Application No: AB/114/20/PD
Site Address: Riverside House 2 Fitzalan Road Arundel BN18 9JS
Description of works: Notification for Prior Approval under Schedule 2 Part 1 Class AA for a additional 2 storeys on existing dwelling house.

Thank you for your internet representation made on 30th November 2020 which has been recorded as an objection with the comments as follows:

PROPOSED ROOF PLAN

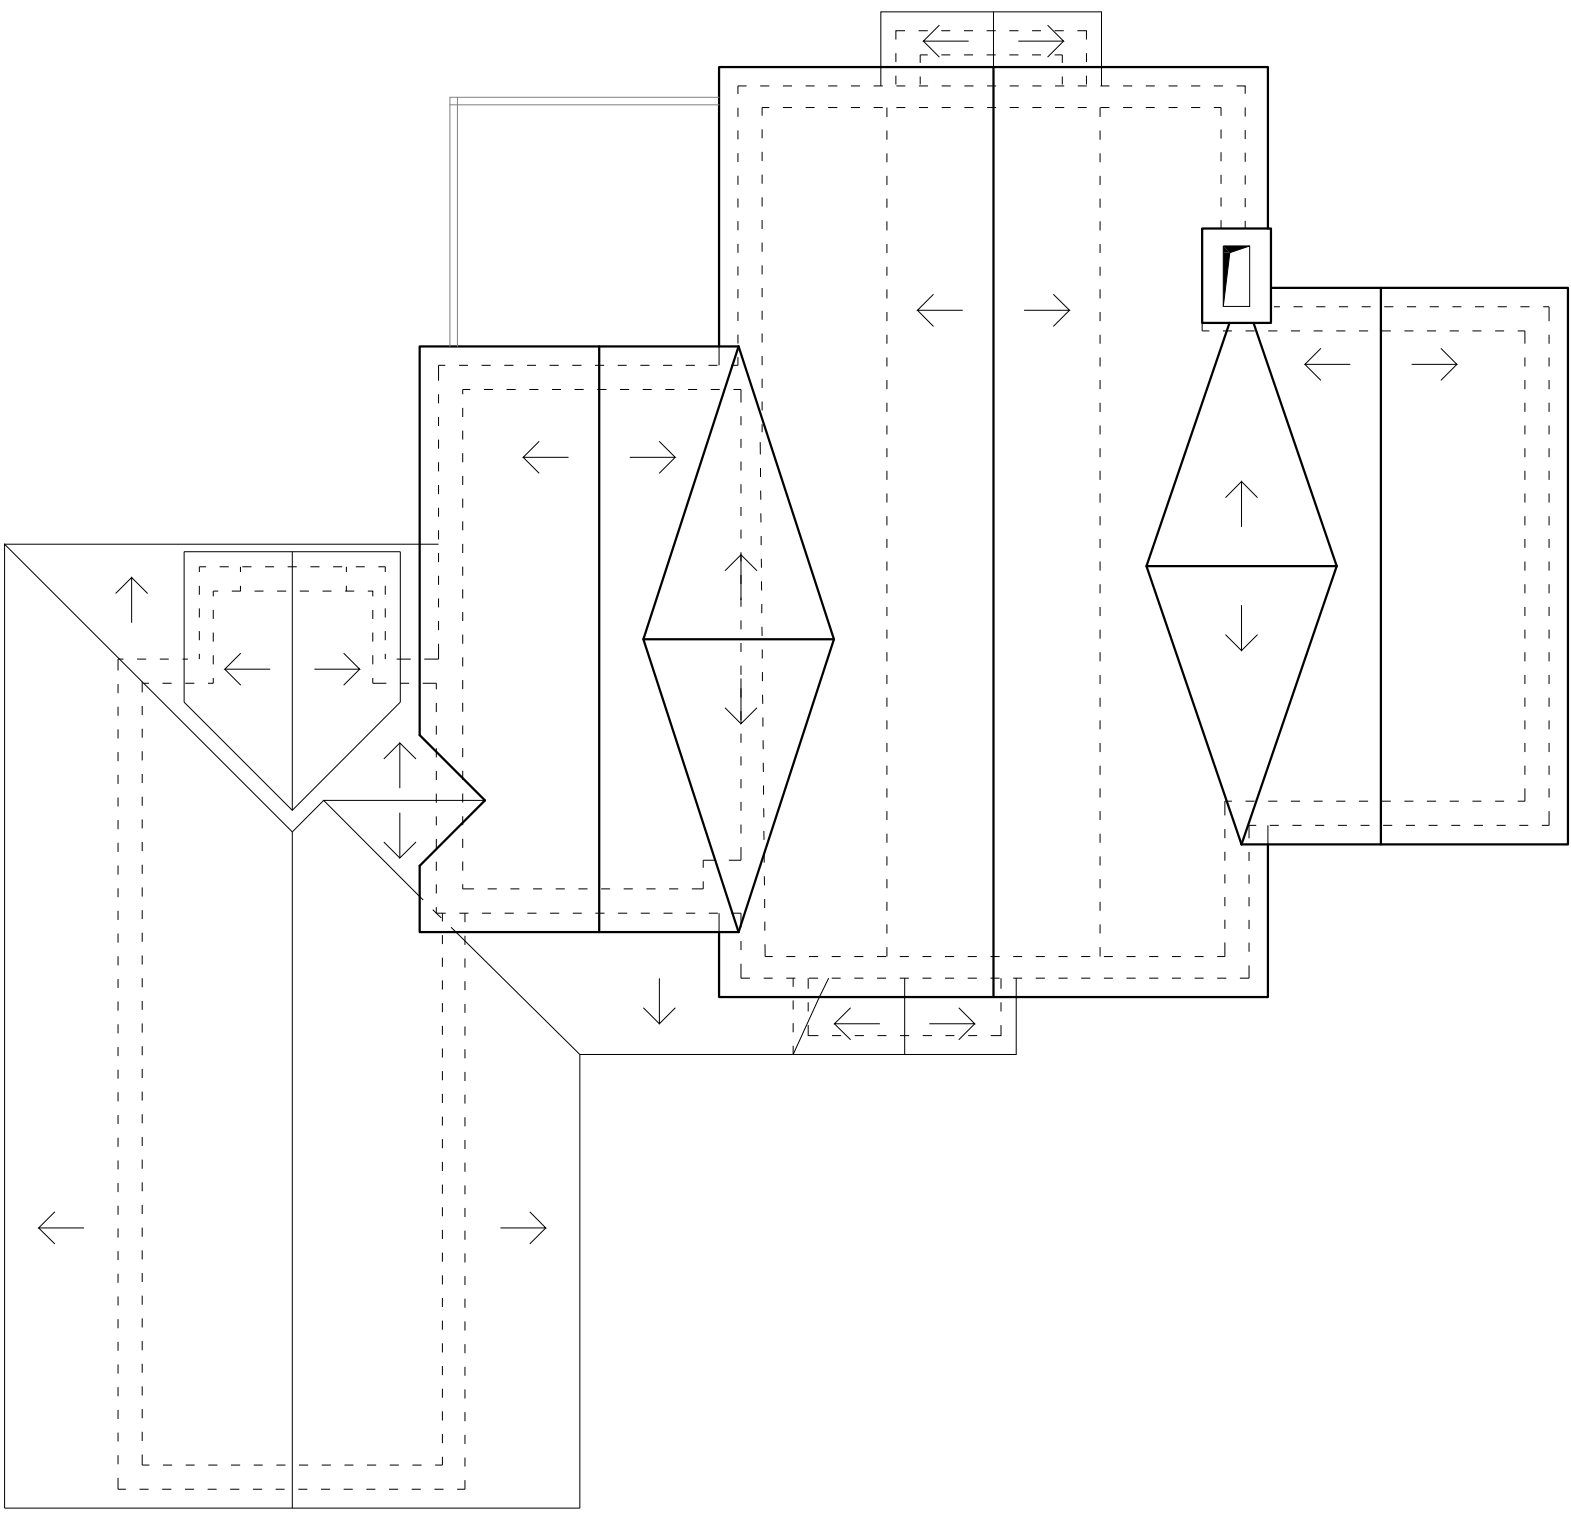
- suprisingly, it is planned for there to be eleven sanitary facilities, although one bathroom is shown as not fitted out;
- there eleven rooms designated for diverse activities e.g. snug, games room, library;

- there is no connection between the core of the house and the top three floors of the extension above the Home Office;
- the height of the extended dwelling will be disadvantageous to the Council's planned housing development of the Blastreat property and the blank wall of the south-eastern elevation of the Home Office and above situated close to the road is particularly insensitive;
